From: Christopher Davis
Sent: 09 April 2019 17:11
To: Planning.Responses
Cc: Andrew Wood
Subject: LU/40/19/DOC - Approval of details reserved by condition imposed under ref LU/229/10 relating to Condition No 18 noise attenuation
Importance: High

LU/40/19/DOC

Approval of details reserved by condition imposed under LU/229/10 relating to Condition 18 – Noise Attenuation.
The wording of this condition is noted here for ease of clarity:

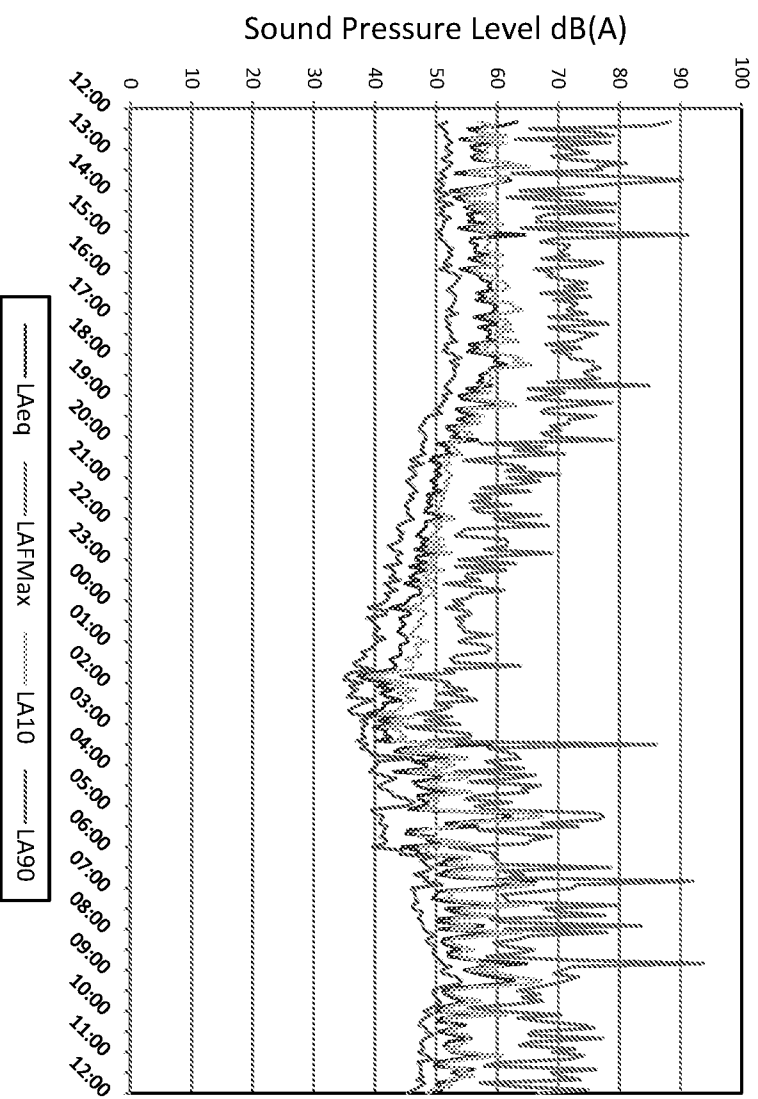
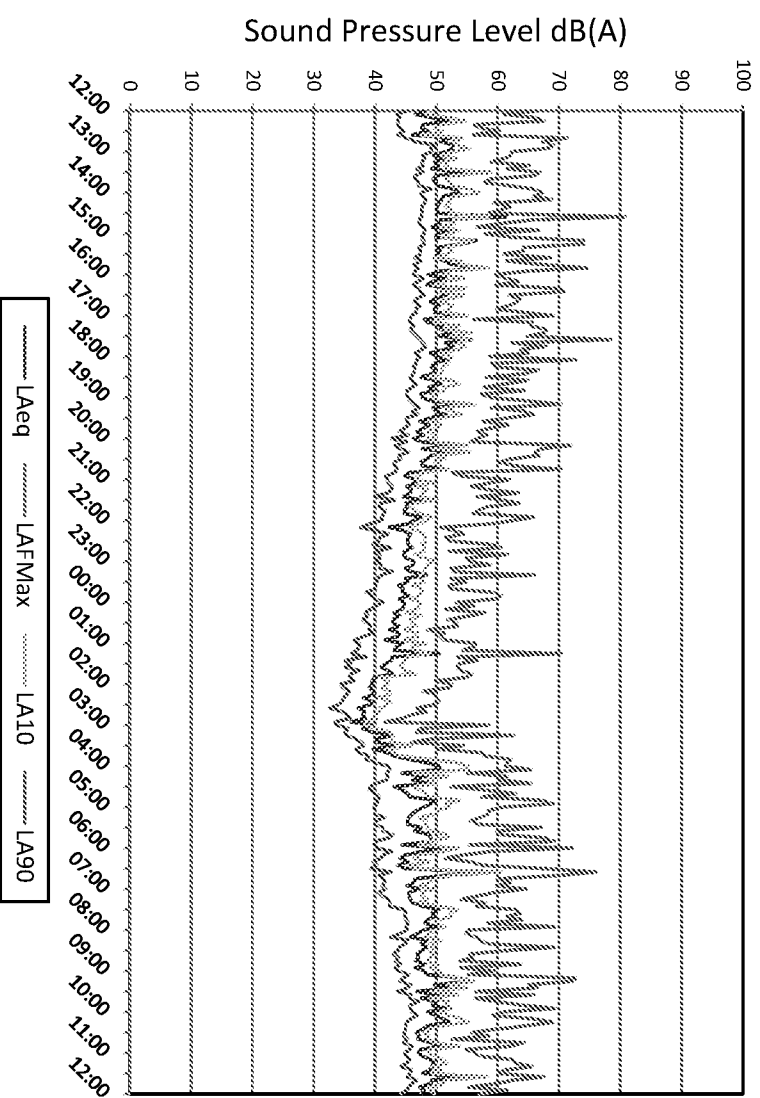
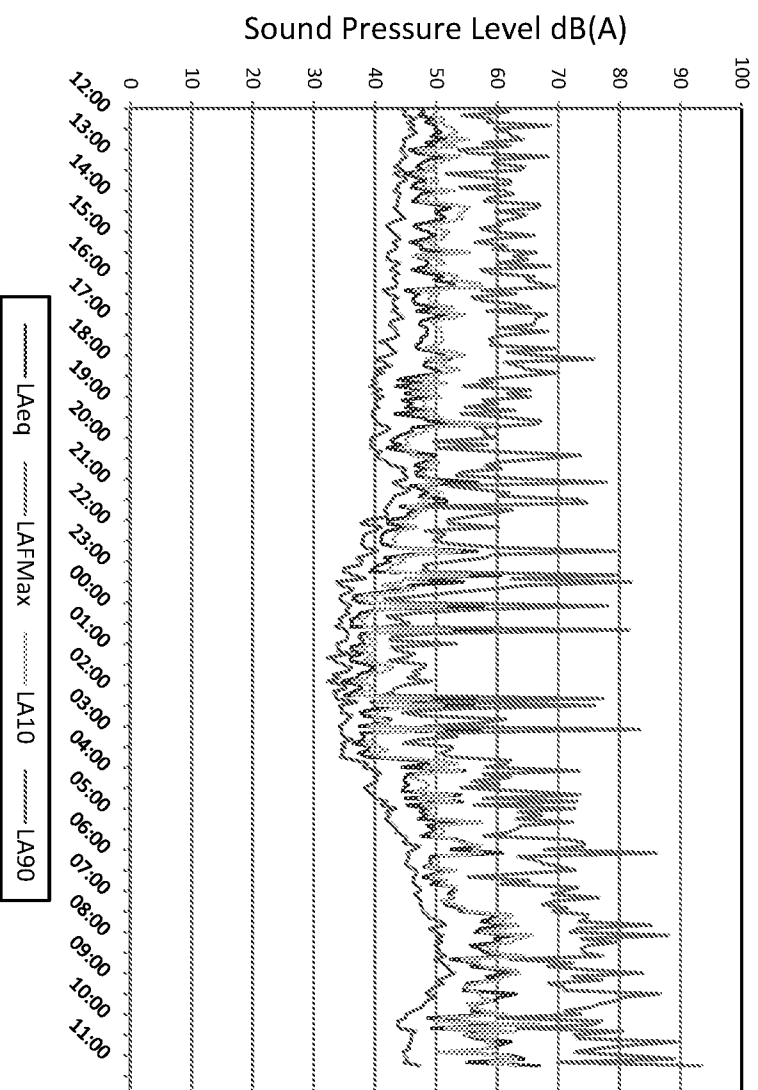
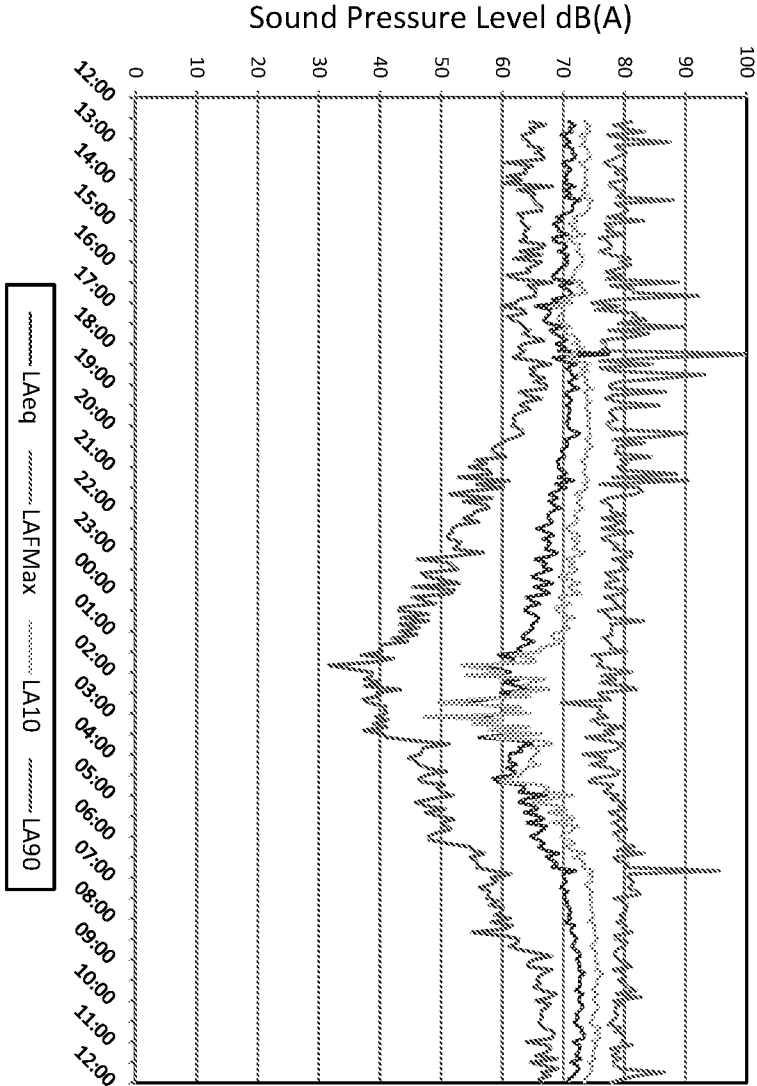
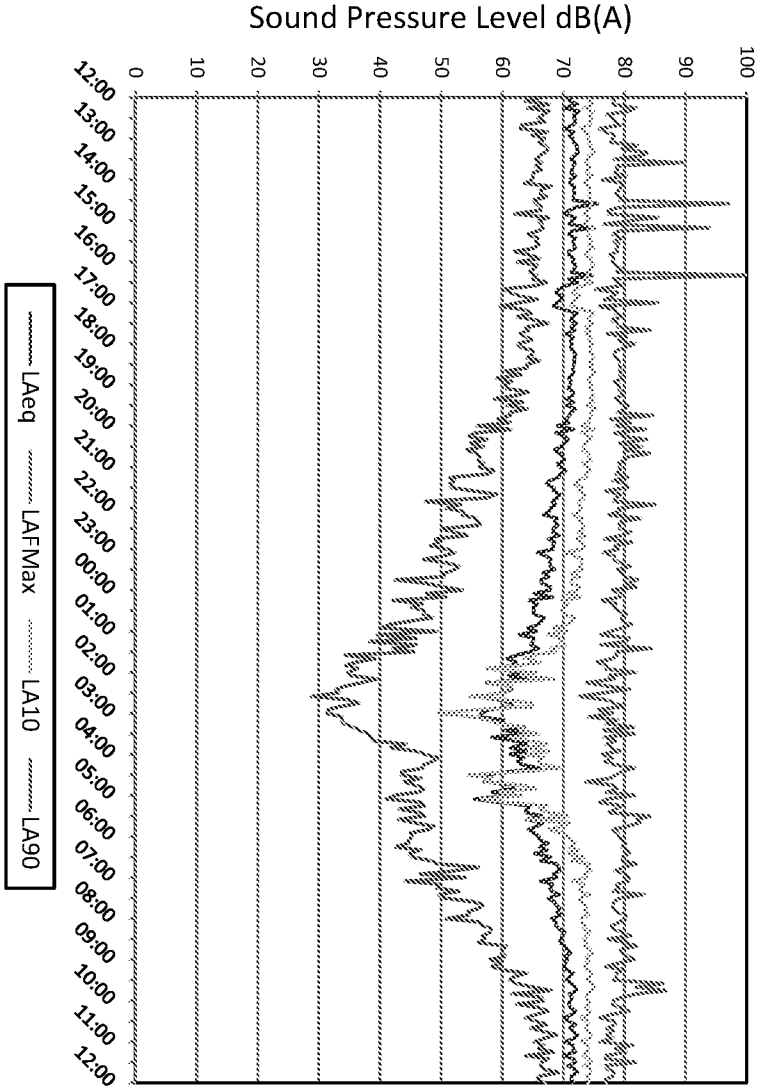
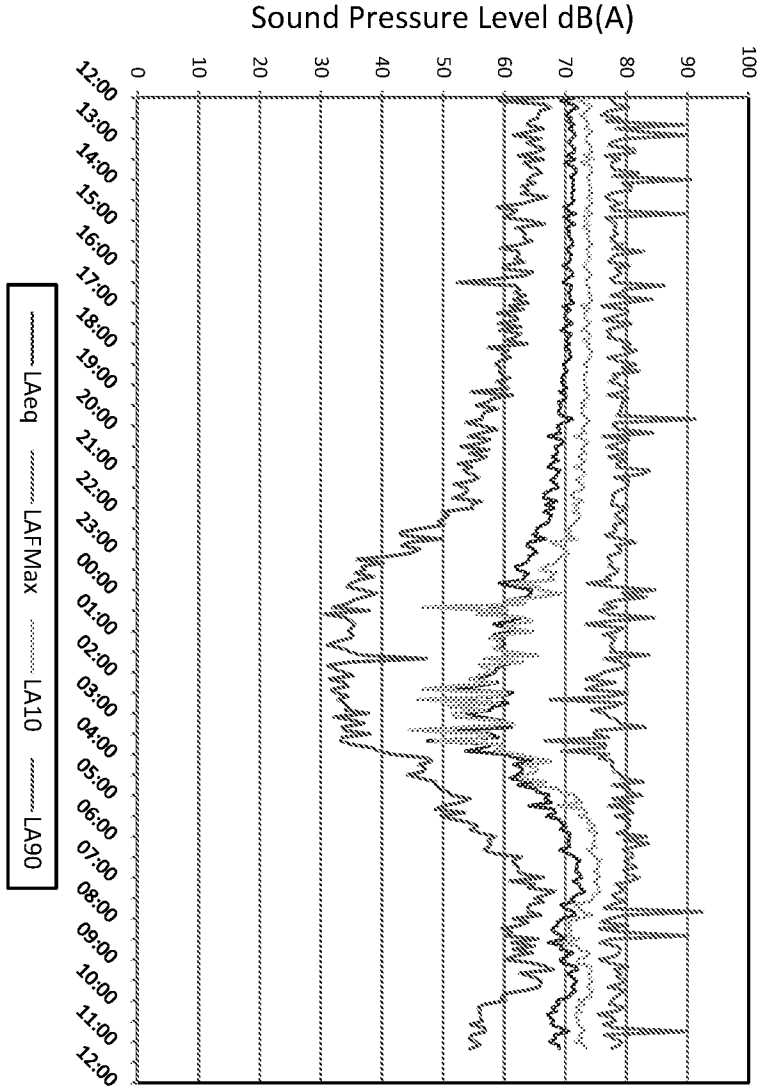
I have read the submitted; *Noise Impact Assessment (Feb 2019) Ref: AS7839.190129.NIA2.0* – as submitted for assessment to the Local Planning Authority and I'm disappointed to see that the gathered noise data was taken between 12:30 on Friday 6th June and 11:15 on Monday 9th June 2014 (some c.5 years prior to this report production). One would have expected a data set slightly more current to take into account any changes in traffic flow densities etc. The report also sights the World Health Organisation (WHO) Guidelines for Community Noise (1999) but fails to consider the WHO Environmental Noise Guidelines (2018 – as amended).

Having said this and after trying to make contact with David Innes of Blueprint Planning, I have read the report and considered the time lapse in the data set as presented. I also have good knowledge of this proposed site and the current noise climate in this area therefore I am now satisfied that Condition 18 of the LU/229/10 application to which this application (LU/40/19/DOC) applies; can be discharged.
